The Planning Inspectorate
Temple Quay House
Bristol
BS1 6PN

Our ref: XA/2025/100350/04-L01
Your ref: EN020026
Date: 10 February 2026

ENVIRONMENT AGENCY RESPONSE FOR DEADLINE 4.

SEA LINK, EAST ANGLIA AND KENT

Plate 2.4 Potential floodplain compensation provision locations

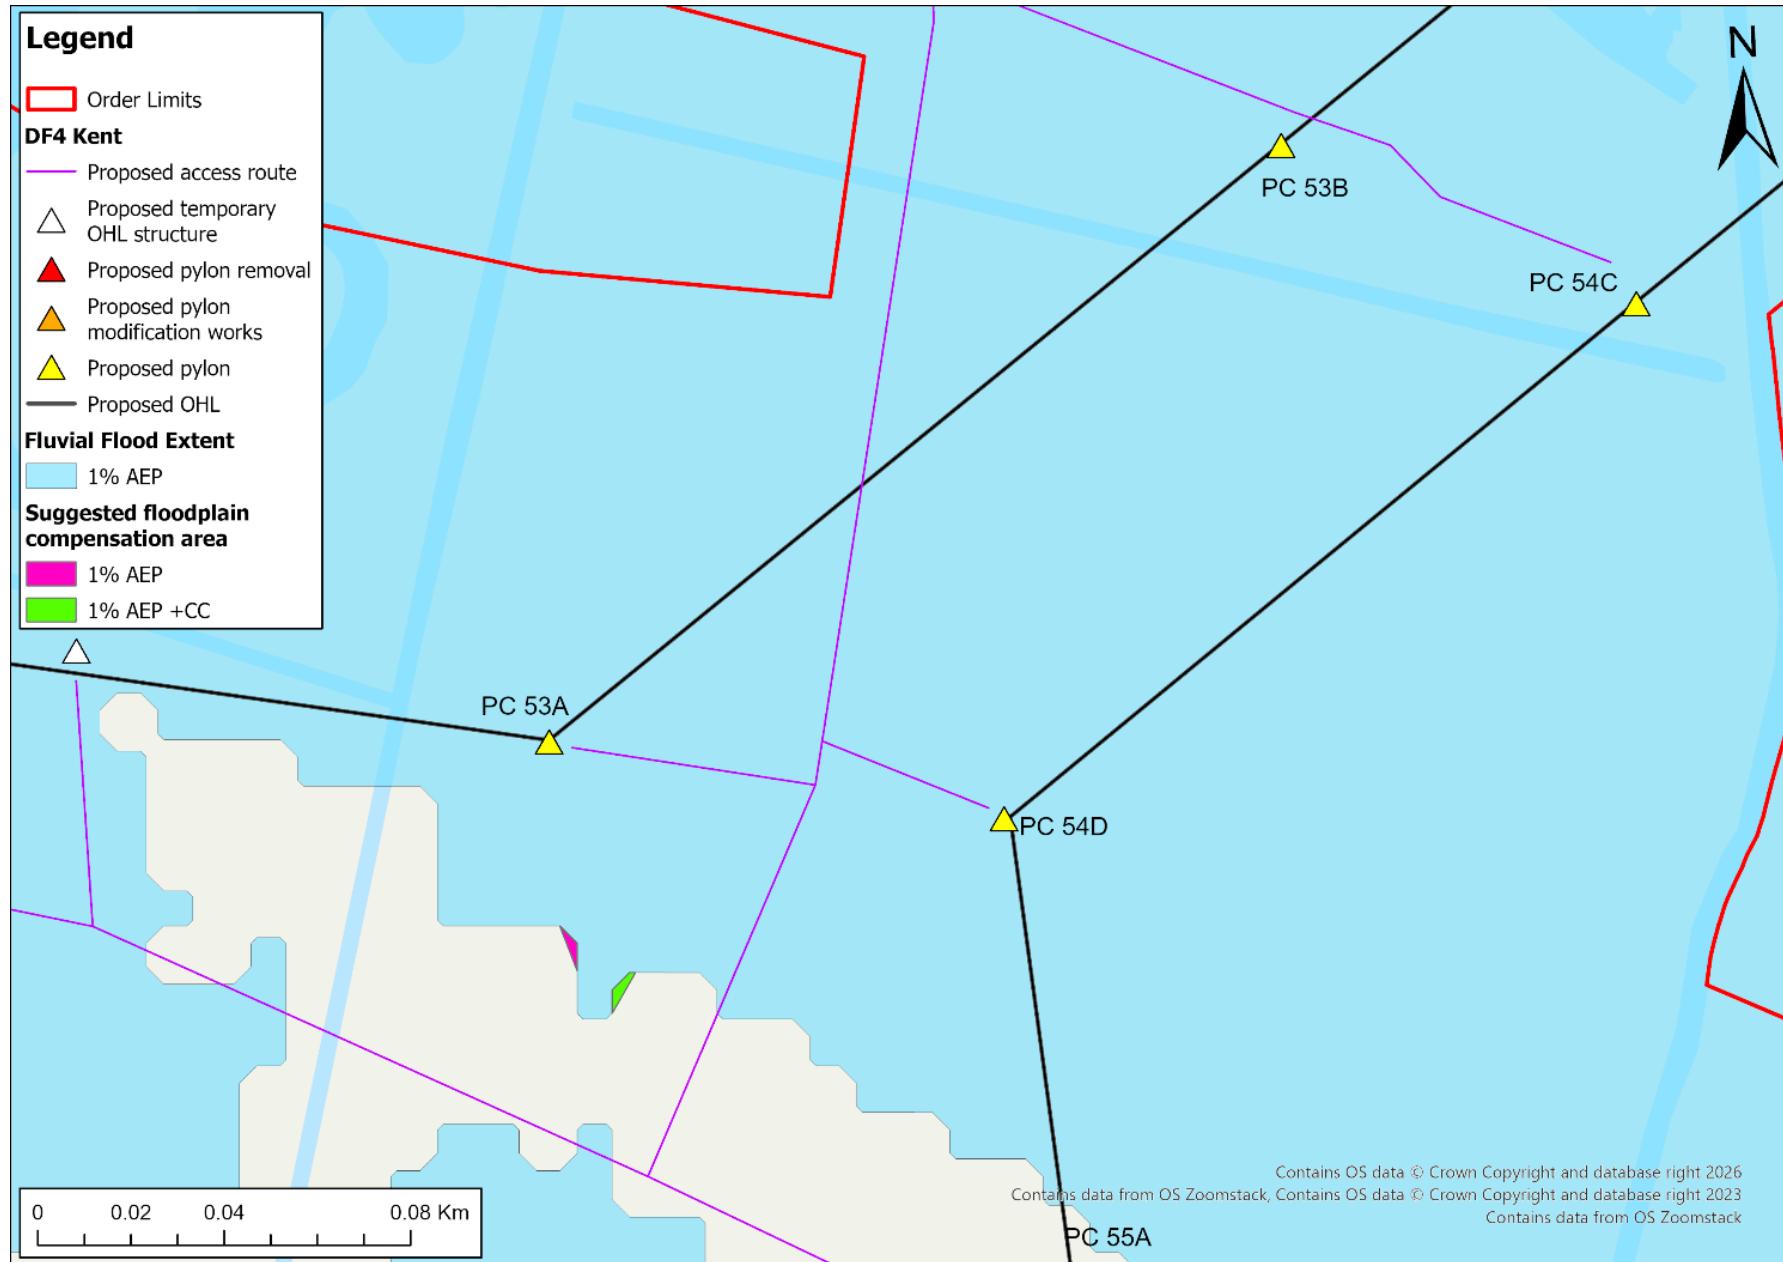
We note that an ordinary watercourse falls within the proposed converter station’s boundary, and thereby means that the converter station falls partly within fluvial and tidal flood zones 2 and 3. As per our requests under EA065, EA069, EA070 and EA075, we require compensatory flood storage for all areas falling within the floodplain (specifically fluvial floodplain for the river Stour).
